Our reference: P-437150-H7T7
Contact: Kathryn Saunders
Telephone: (02) 4732 8567

1 February 2023

Modification Application - Orchard Hills Waste Facility - Integrated Water and Leachate Plant Modifications - (MP09_0074-Mod-2)

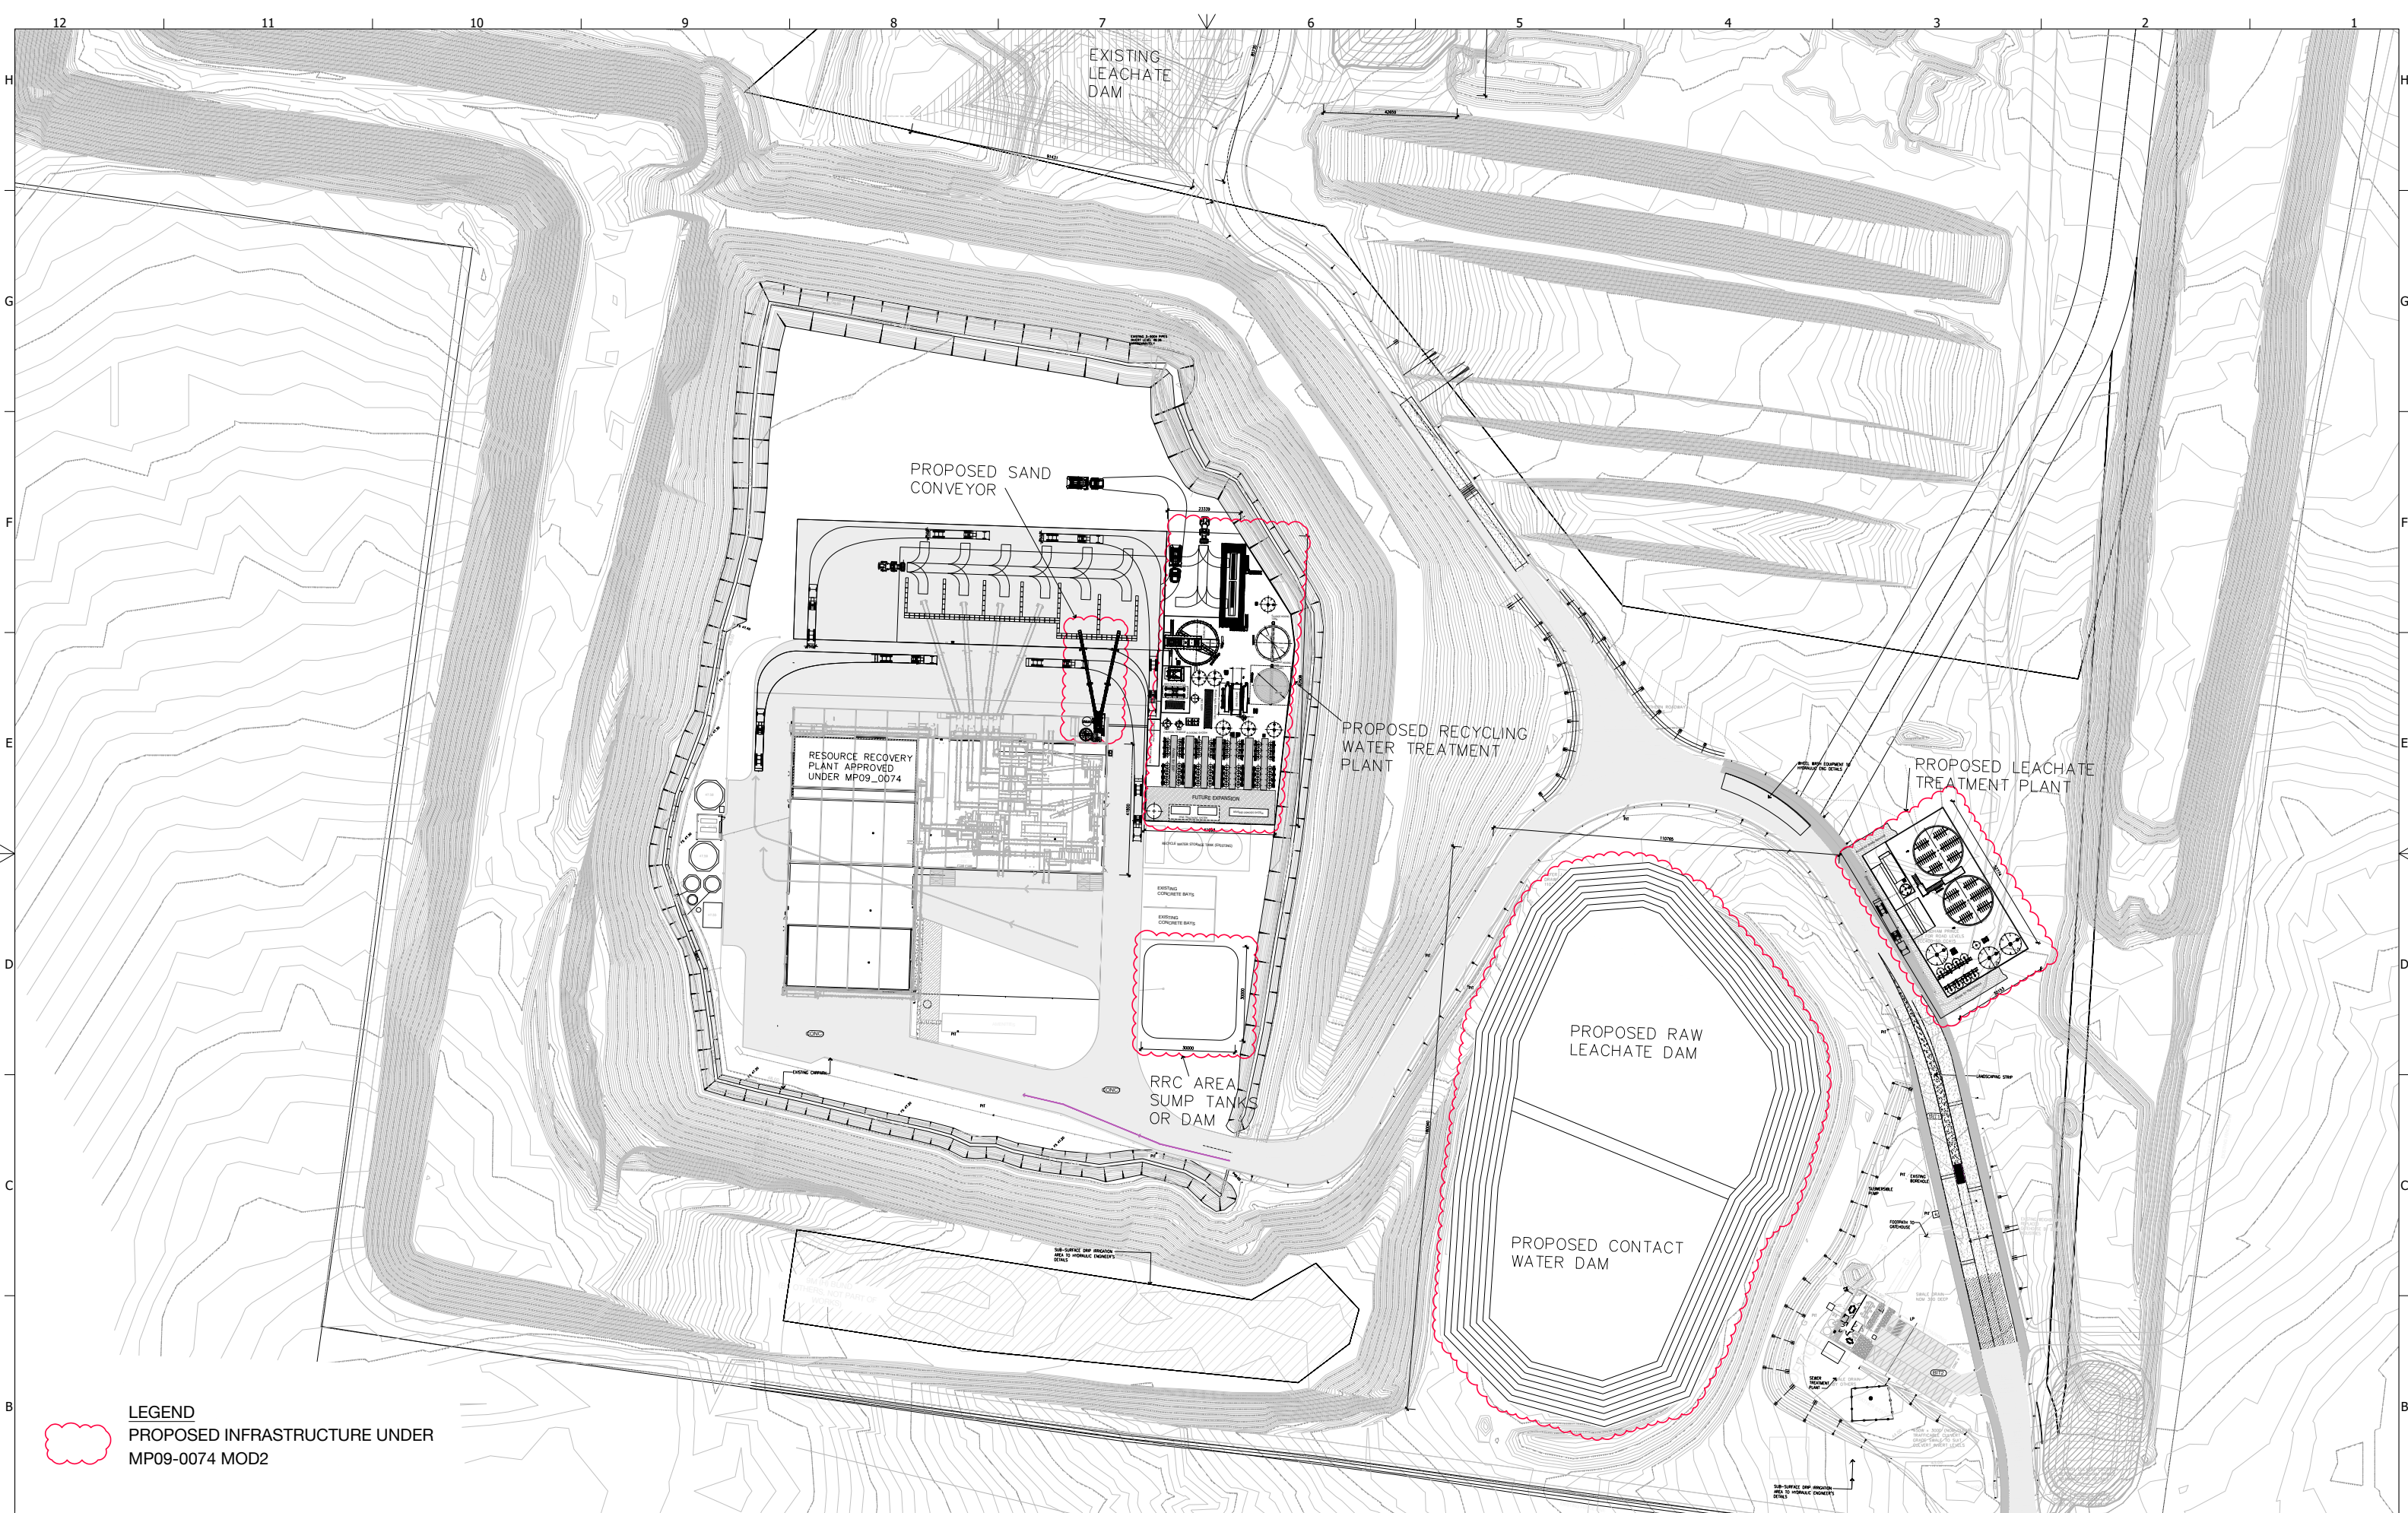
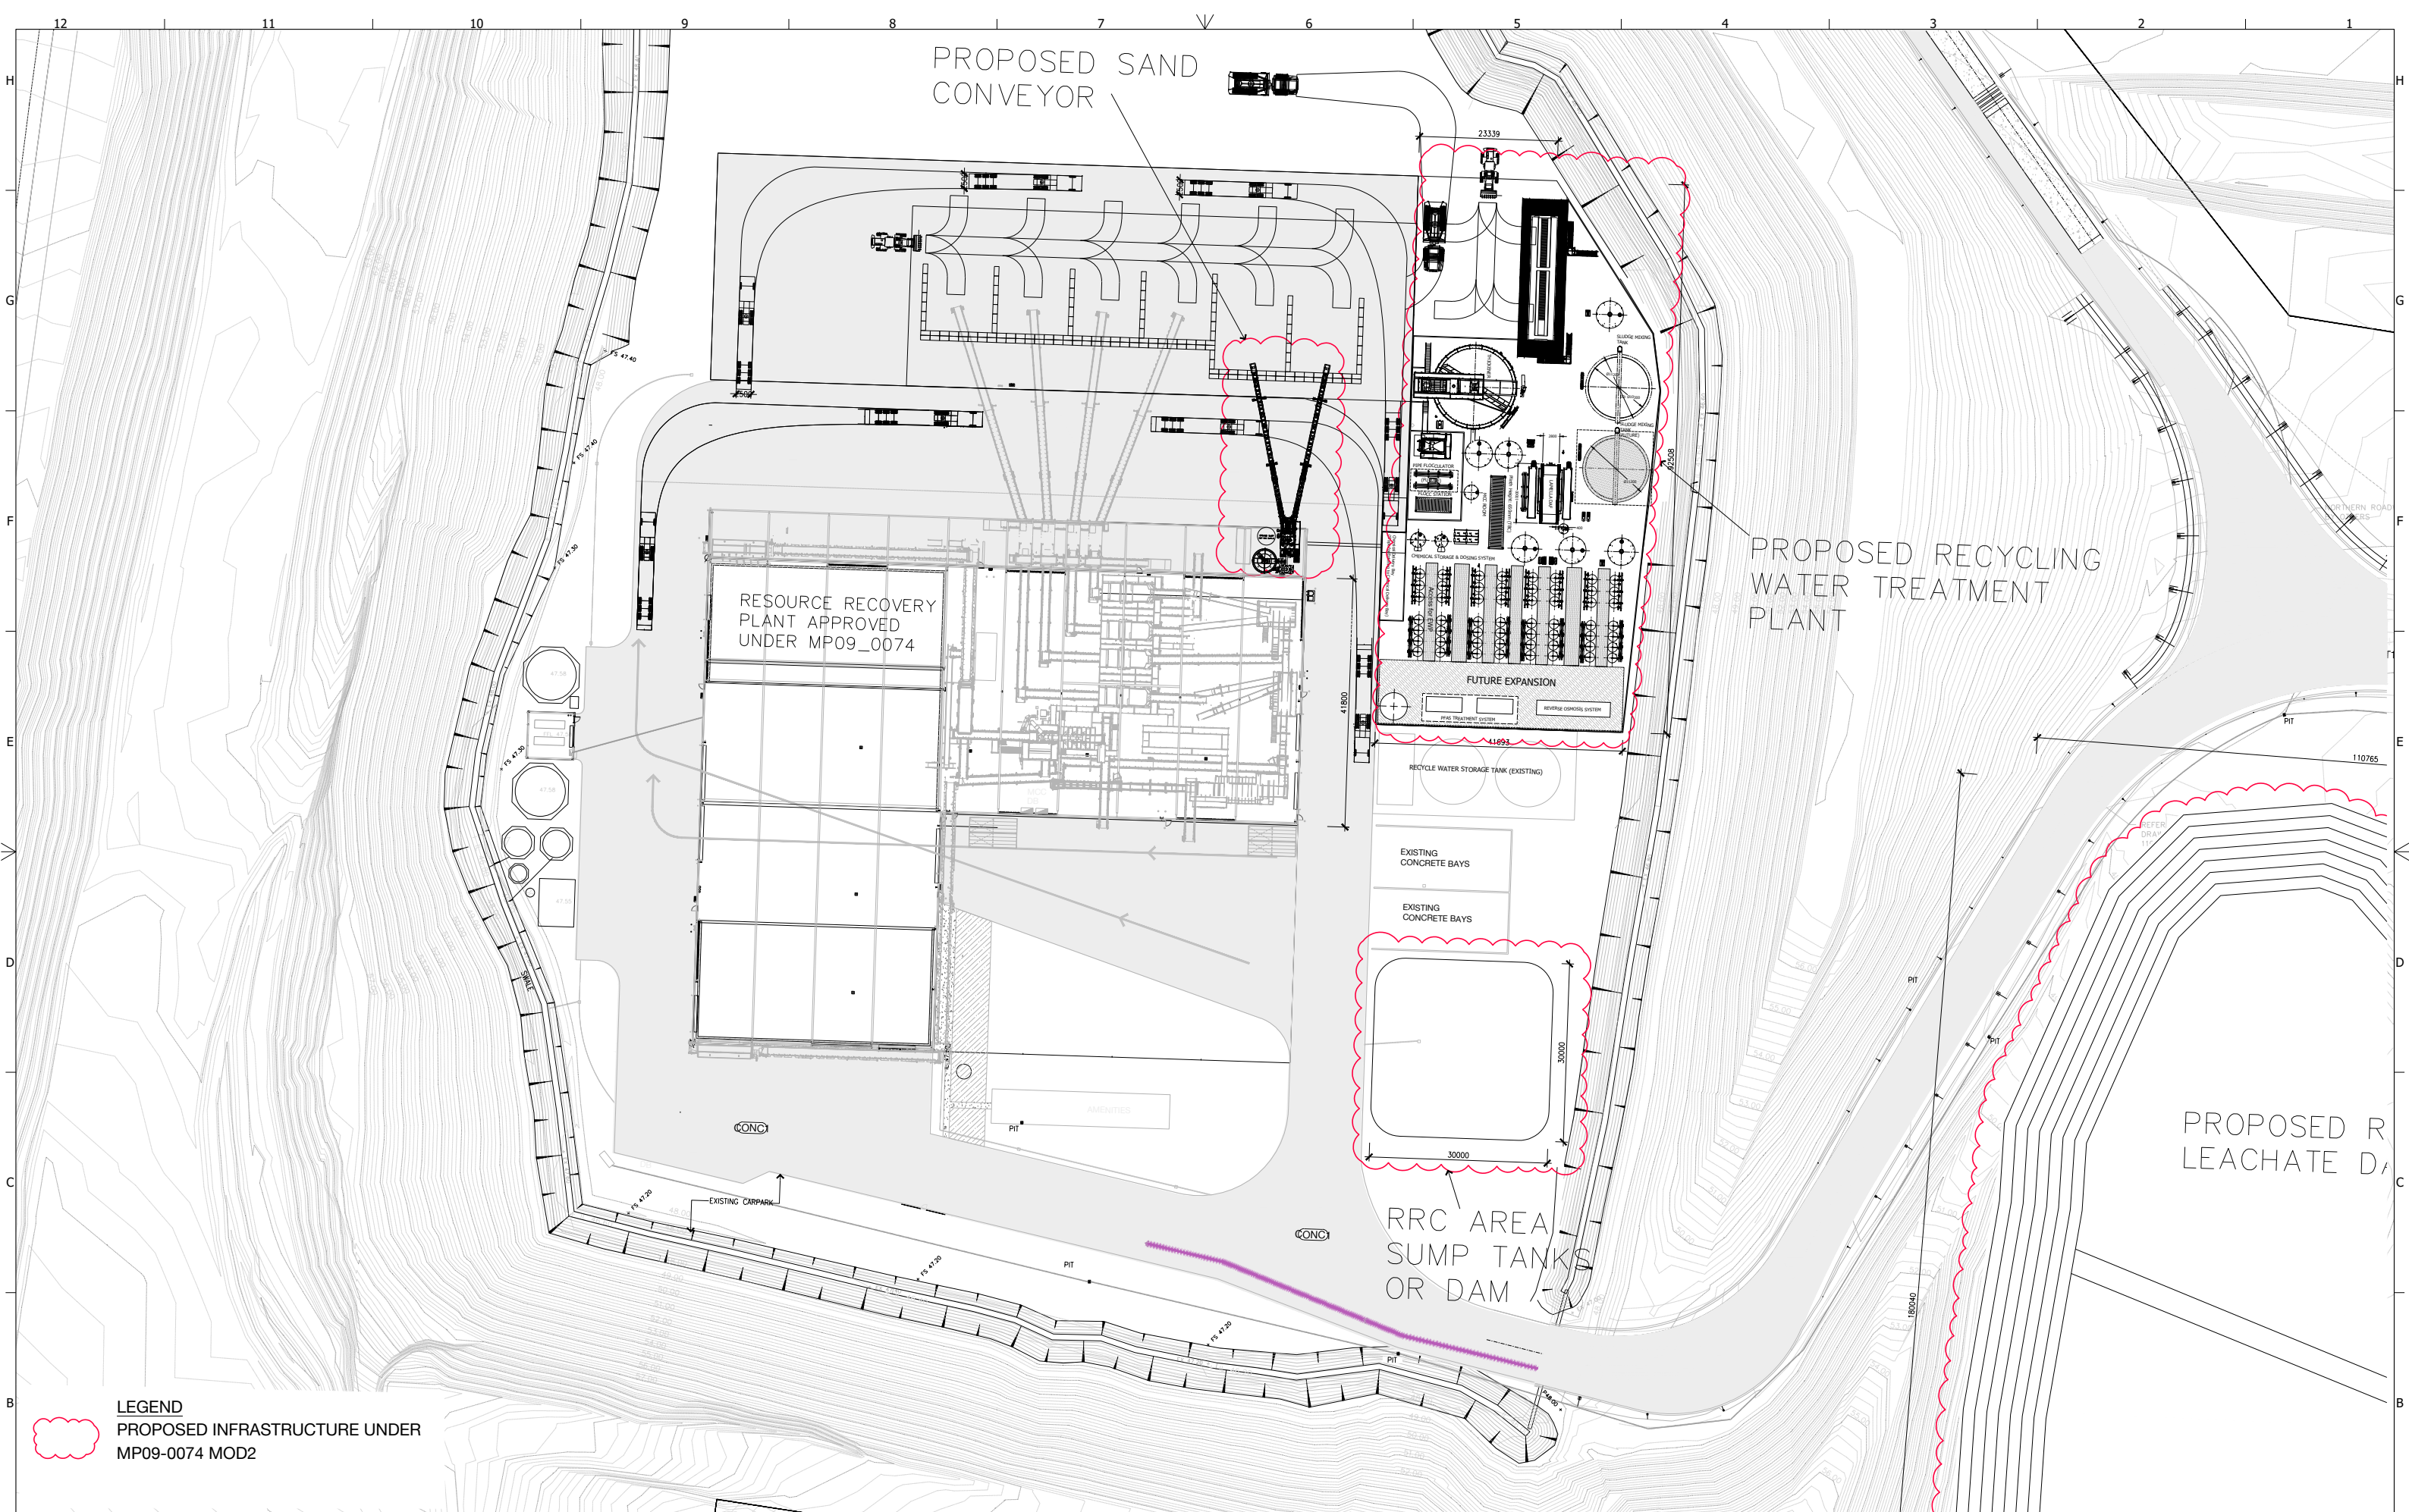
The plans and Modification Report do not detail the maximum heights of structures. It is recommended that DPE request the submission of a Visual Impact Assessment which demonstrates that the site will not have detrimental or detracting visual impacts in the location, as view from the future Metro corridor and from surrounding vantage points.

Elevation plans are to be provided for the Department's assessment and the materials and colours of all new tanks and infrastructure are to be nominated.

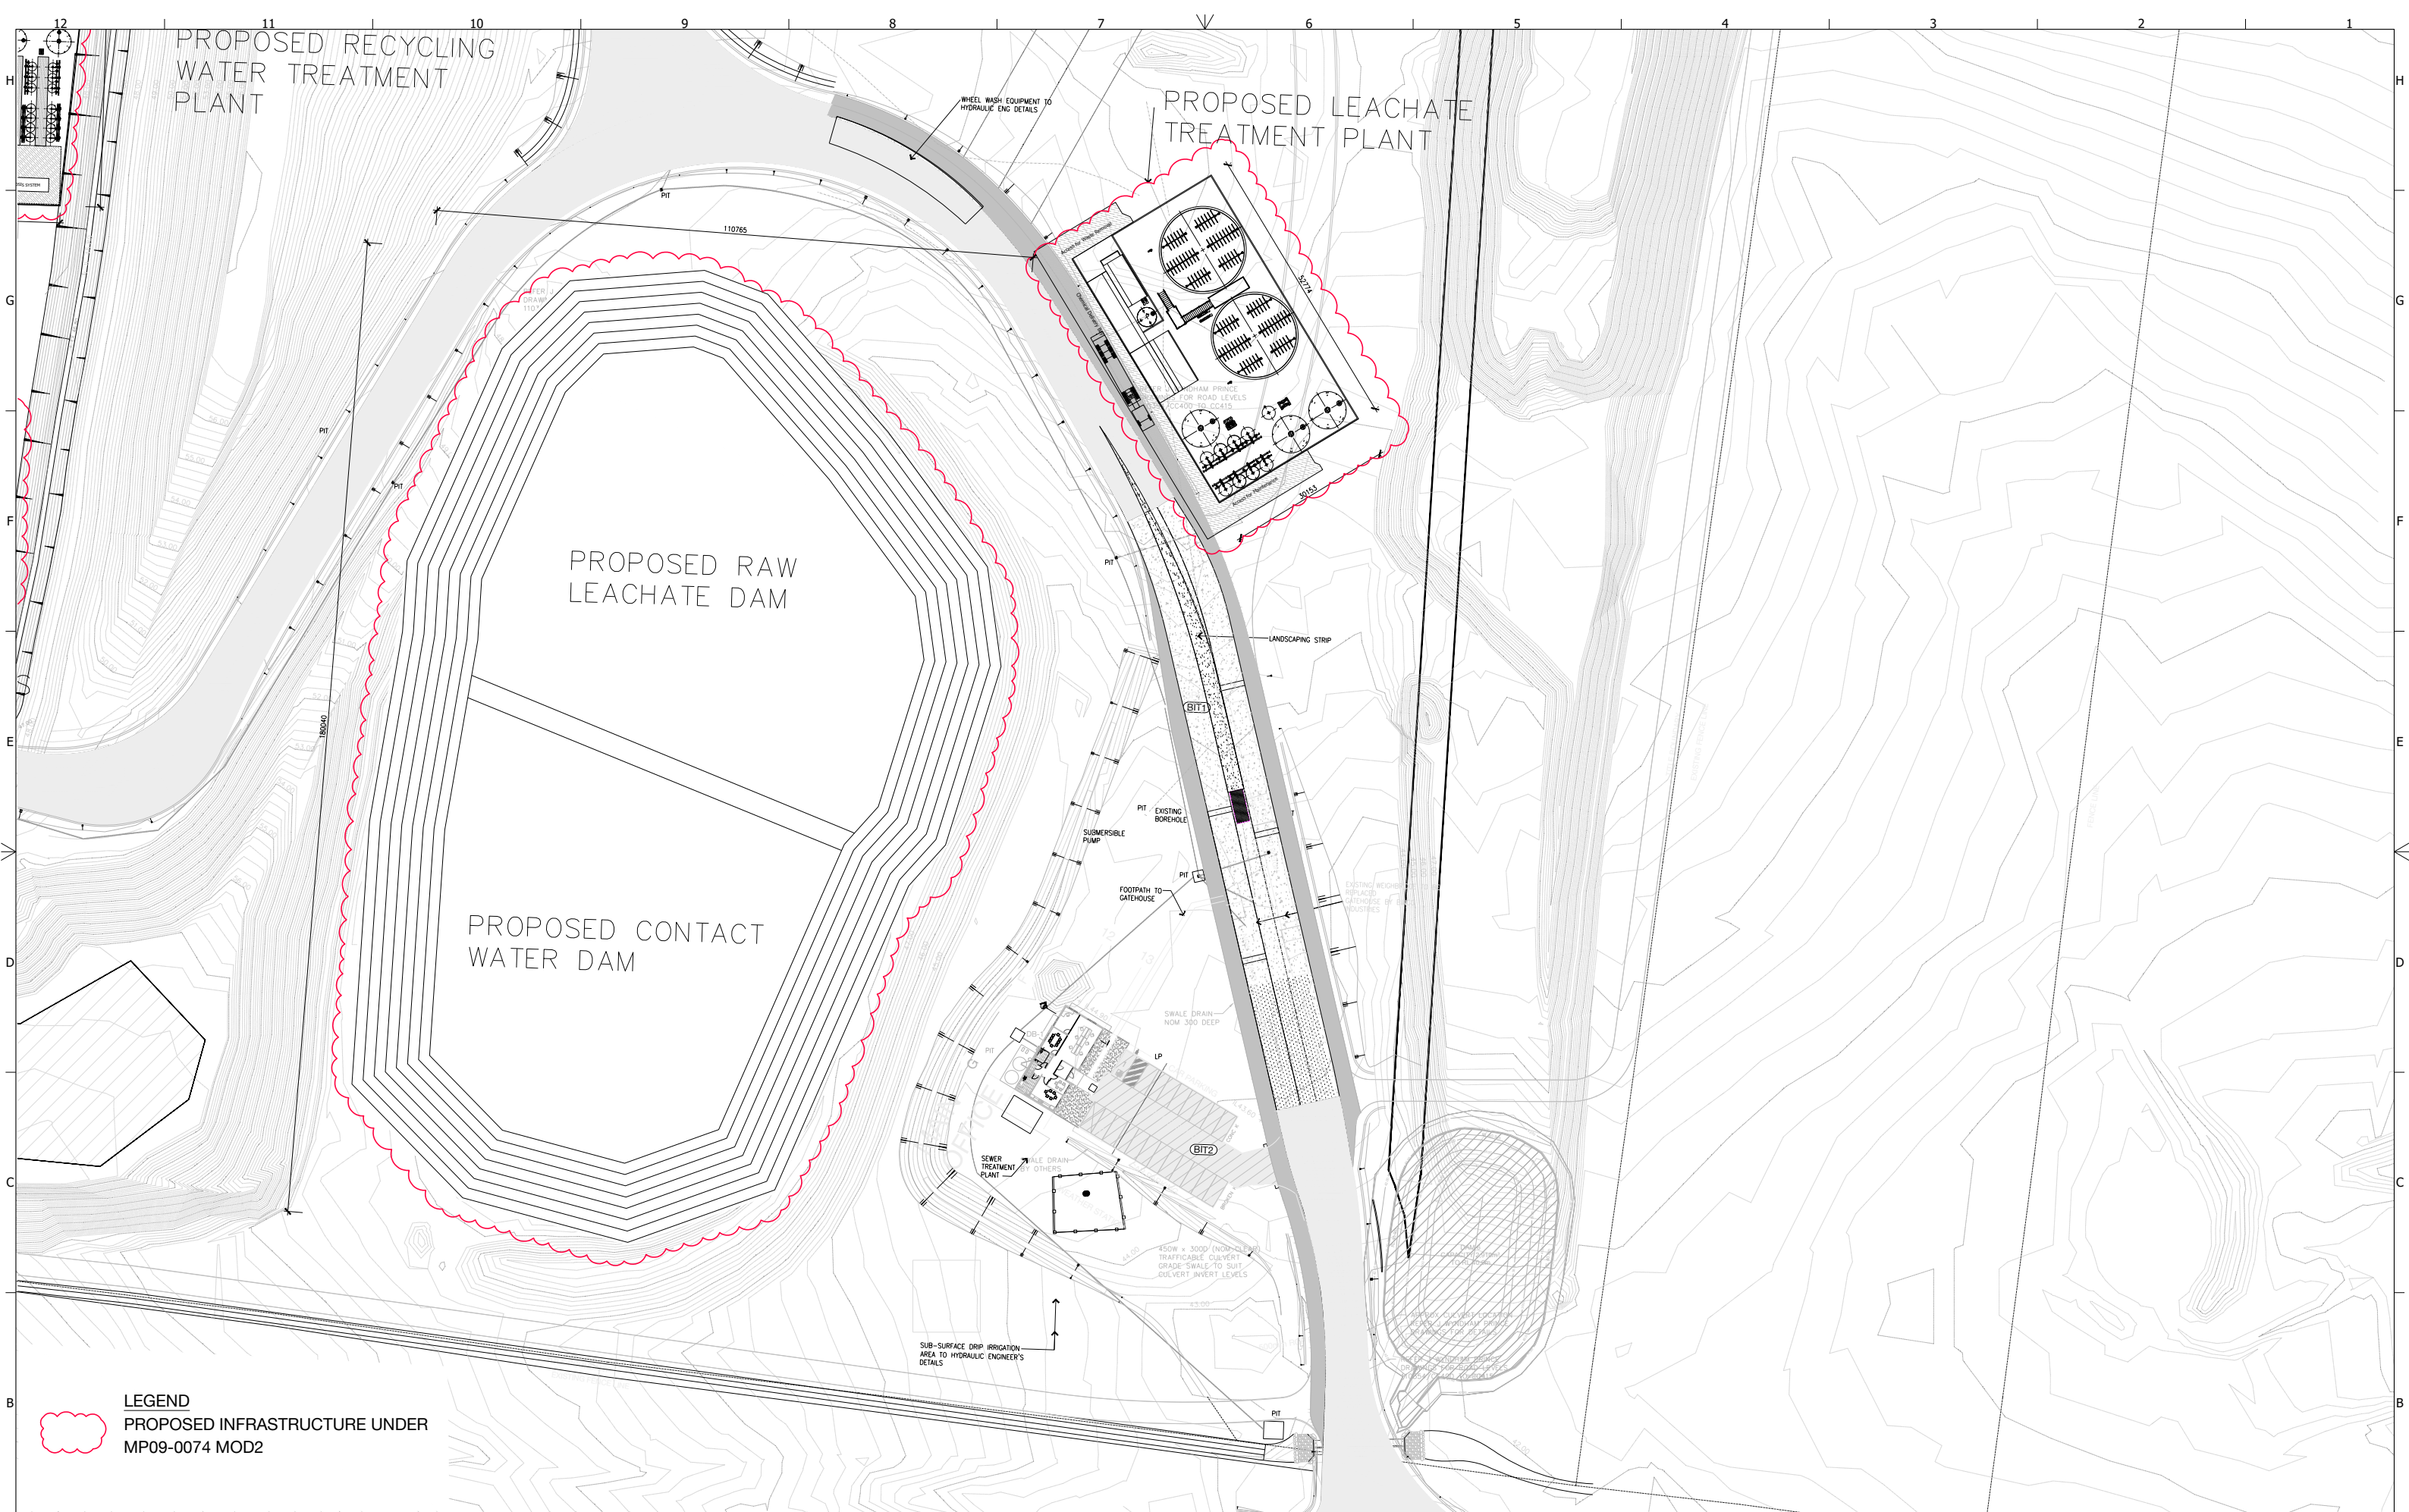
The suitability of the proposed location of the tanks and associated plant machinery close to the eastern side boundary is to be assessed, noting that

visual impacts may result. Passengers on the Metro line should not have a clear view of the treatment plant.
The applicant is to be requested to provide a View Impact Assessment (VIA).
